One Joy Place - Final Traffic Comments

Hi Jean – The following summarizes my final traffic comments as a status update of prior comments following a review of the application materials.

BRICK DRIVEWAY APRON

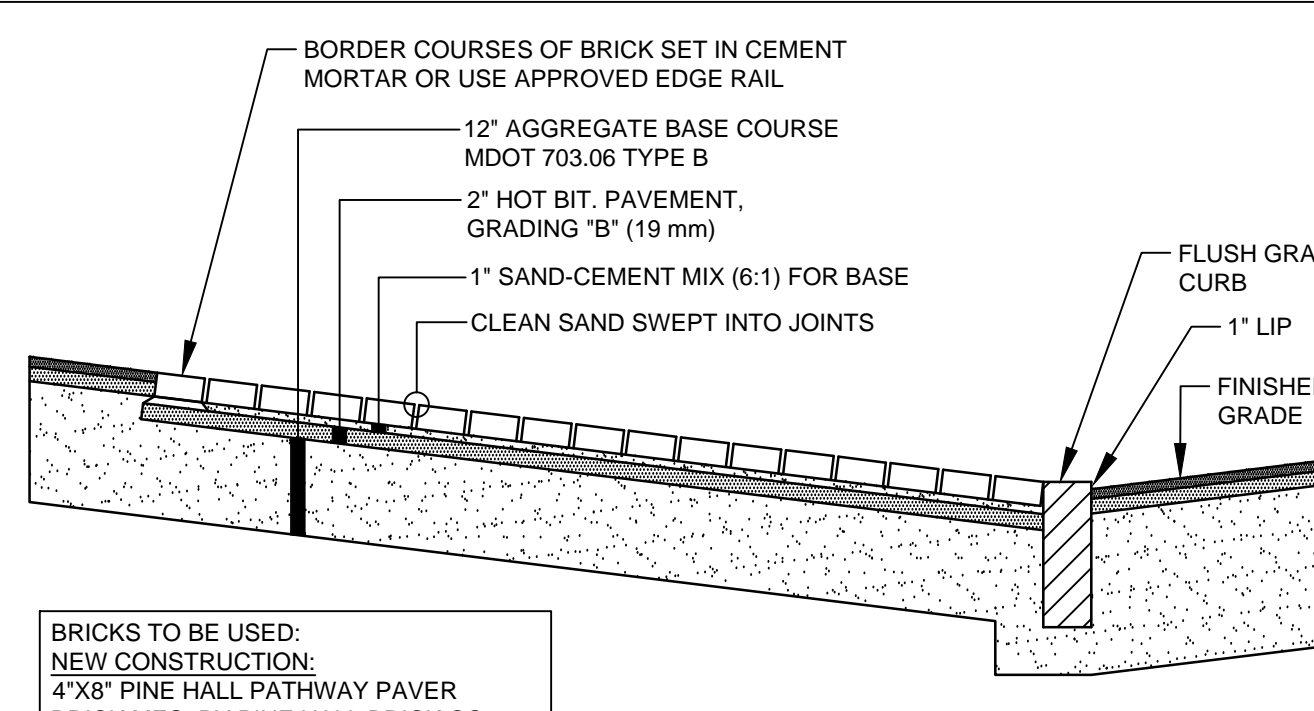
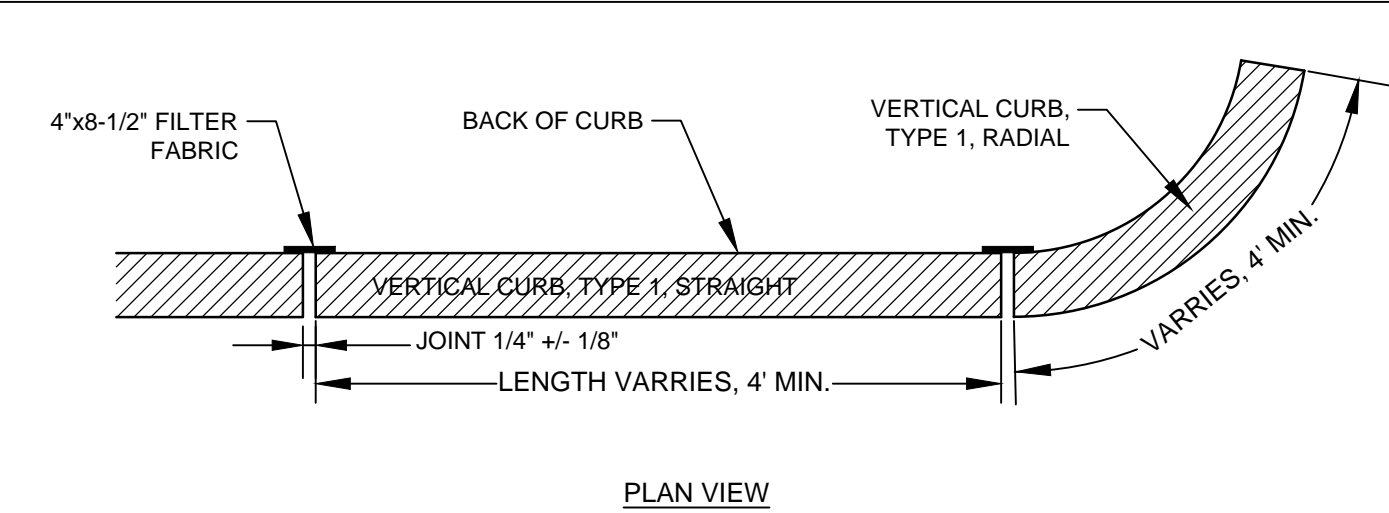
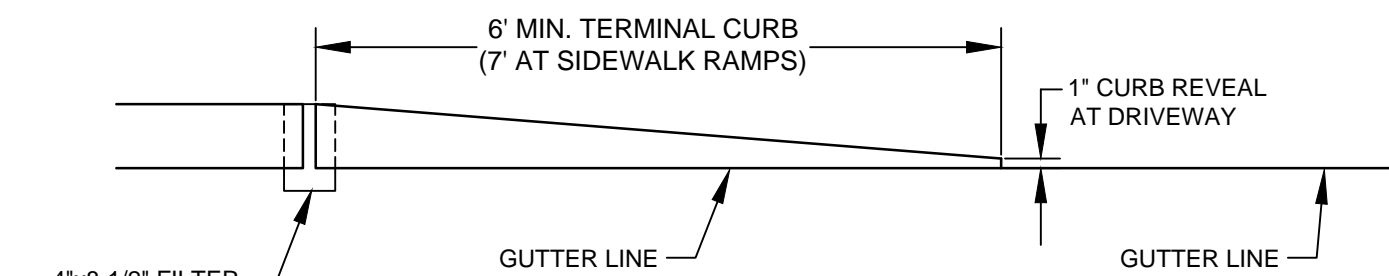
- The driveway apron shall be designed to provide a maximum cross-slope of 2 percent along the pedestrian accessibility route.

Status: The applicant has noted in writing that a 2 percent pedestrian accessibility route cannot be provided along Brackett Street in the Joy Place driveway apron area. The applicant has provided a driveway design detail that specifies a maximum cross-slope of 2 percent for the driveway apron. A condition of approval should reinforce the requirement that the driveway apron shall conform to the design detail provided (2% maximum cross-slope).
